**Consultation Response from KC,
Conservation & Design**

2024/90602 Bryan Wood Residential Home, 1, Bryan Road, Edgerton, Huddersfield, HD2 2AL

Discharge conditions 3 (boundary fencing), 5 (cycle storage), 7 (Arboricultural Method Statement), 11 (bat and bird box) on previous permission 2022/92581 for change of use from residential care home (Class C2) to a school (Class F1(a)) (within a Conservation Area)

Date Responded: 03.06.2024

project: Bryan Wood
Huddersfield
client: Polaris Children's Services
drawing: Boundary treatment +
fences
drawing number: **23-025-15**
revision: A (06-06-24)
date: May 24
scale: 1:500
original size: A3
issue: Approval
drawn: DUJ
checked:

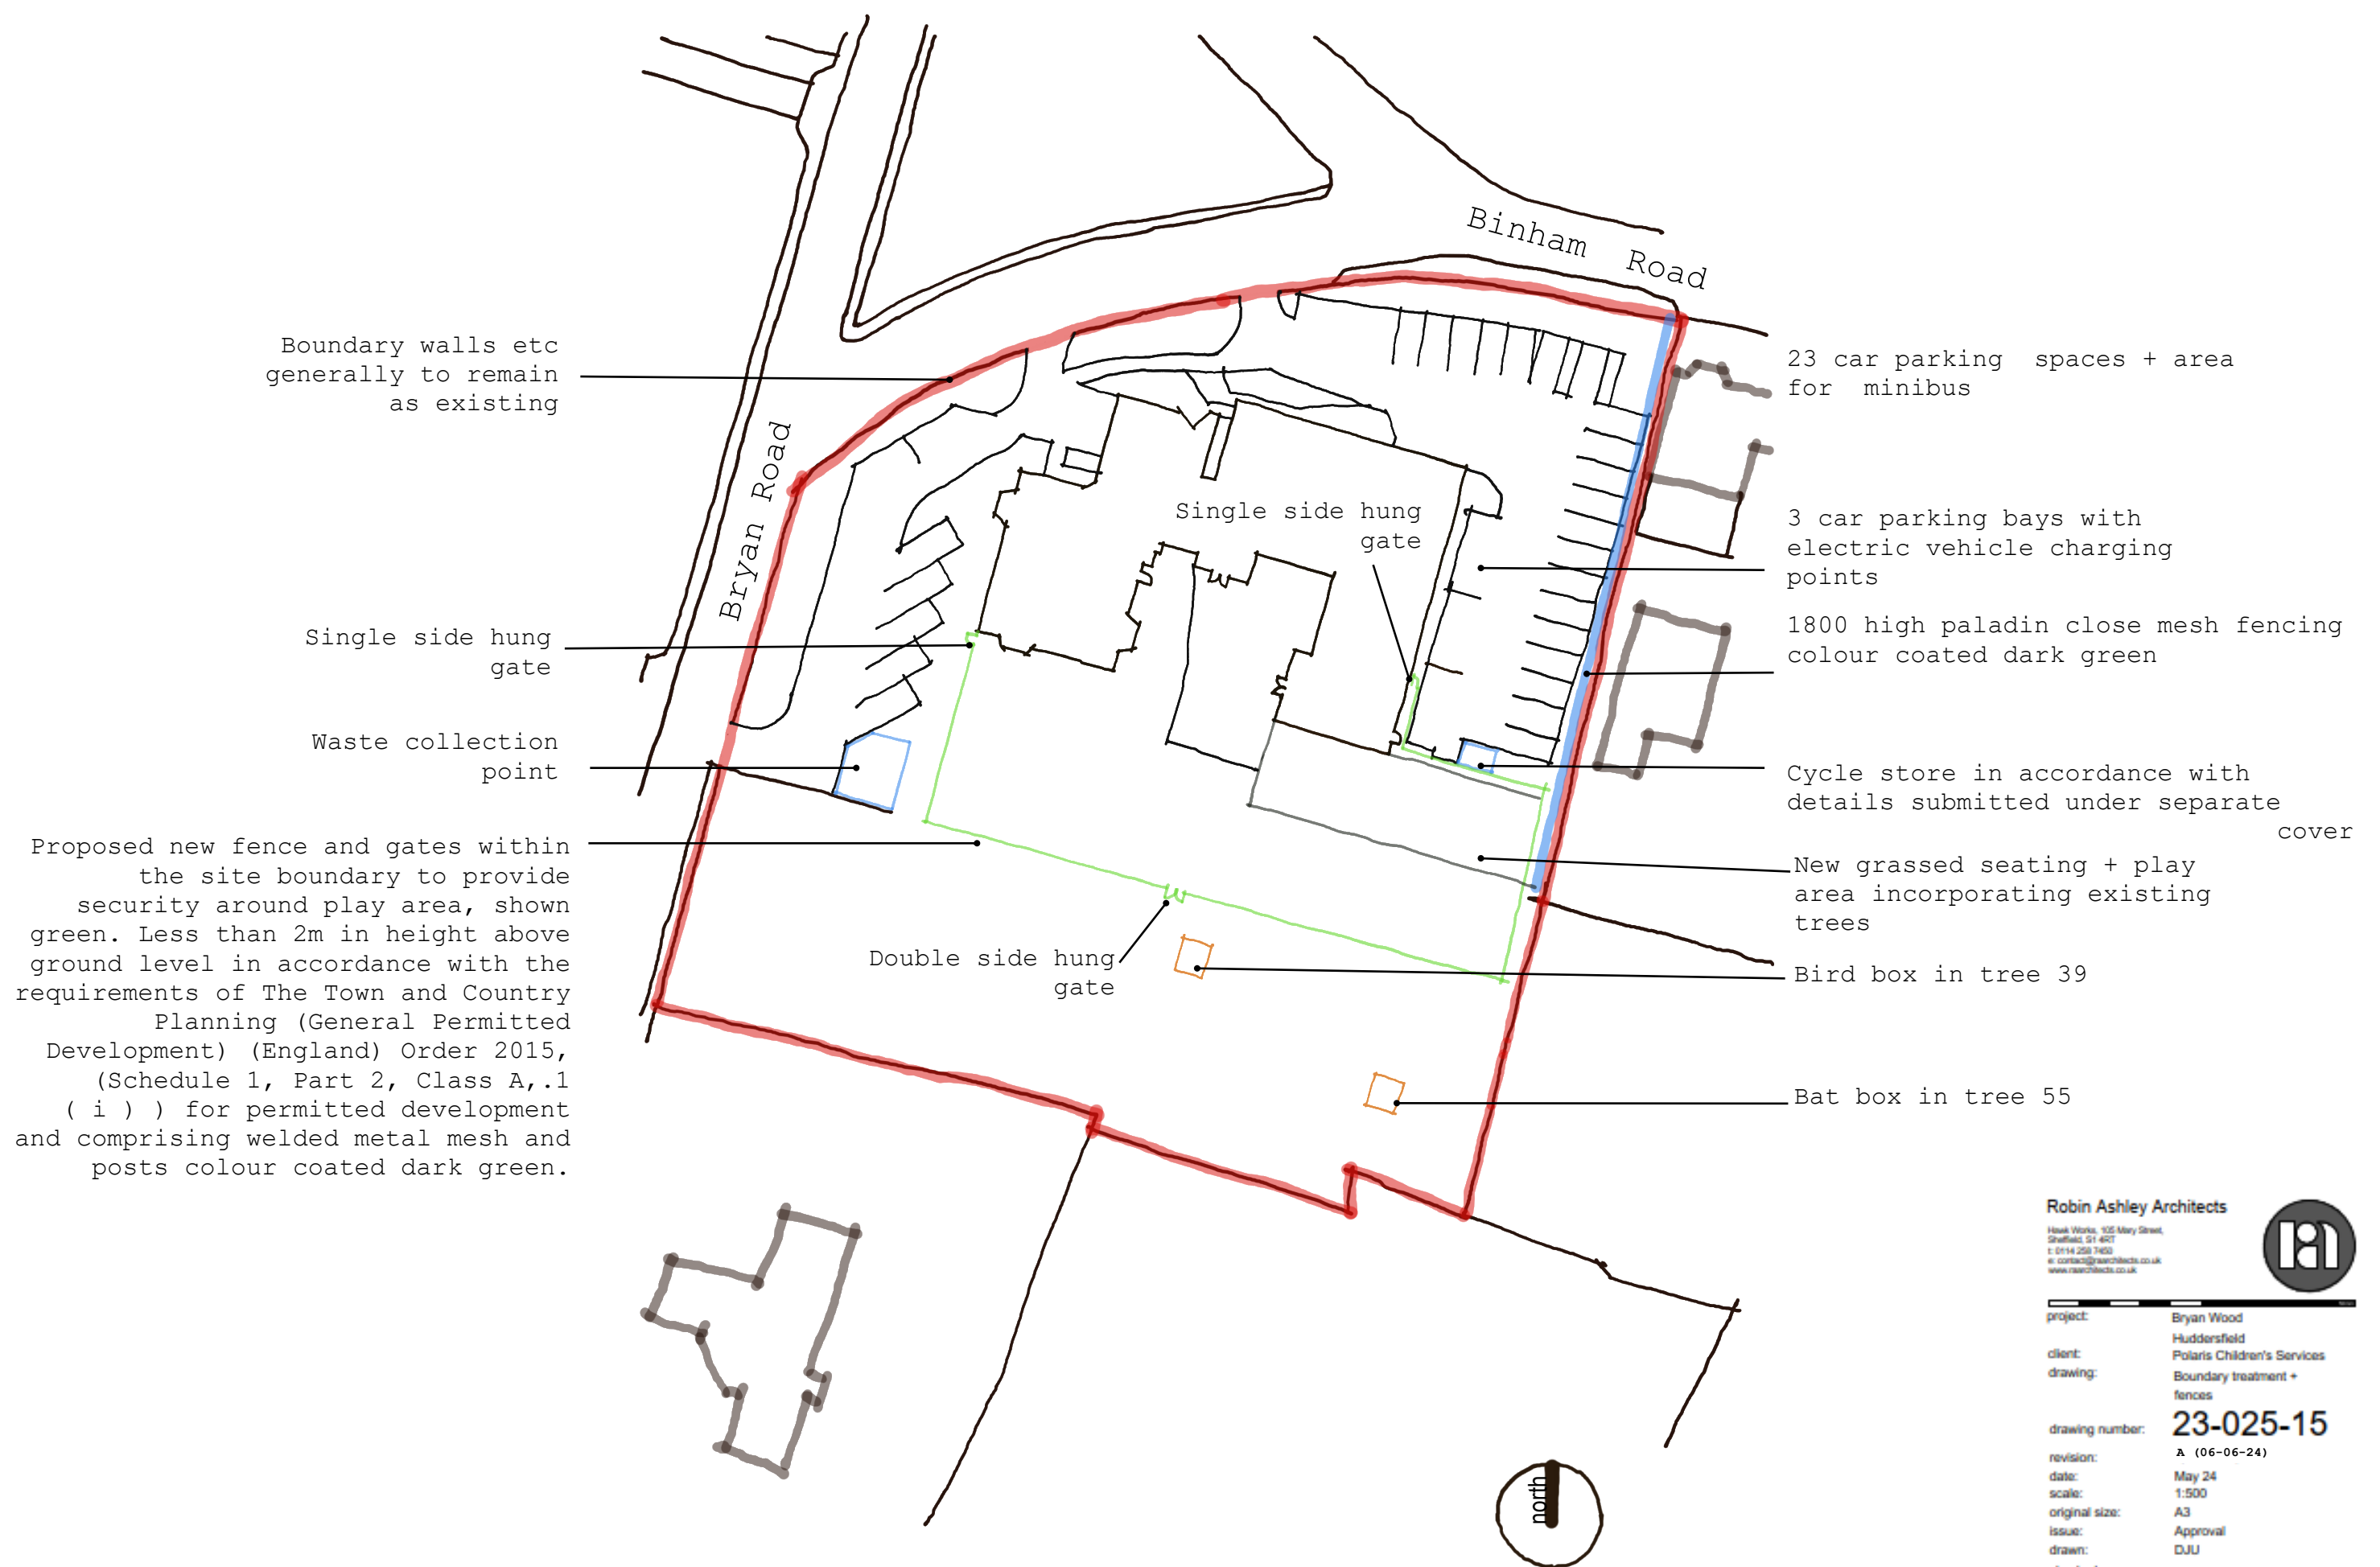
Having reviewed the submitted details we appreciate the requirement for the fencing around the play areas, however, we are not convinced by the proposed featheredge fencing. Having reviewed the area there are few to no examples of such fencing being used and it does not reflect the character of the area. During the months of low/ no leaf cover the fencing will be visible and will create a harsh visual form. Even during the months of full leaf cover, there will be glimpse views of the fencing. We consider that the use of paladin close mesh fencing would be appropriate. It would cover the required security need but create a less harsh visual form with the close-meshed fencing.

The plan states that '*Boundary walls etc generally to remain as existing*'. We would ask for clarification that there are no proposed changes to the boundary walls, saved any that have been agreed under the previous approval.
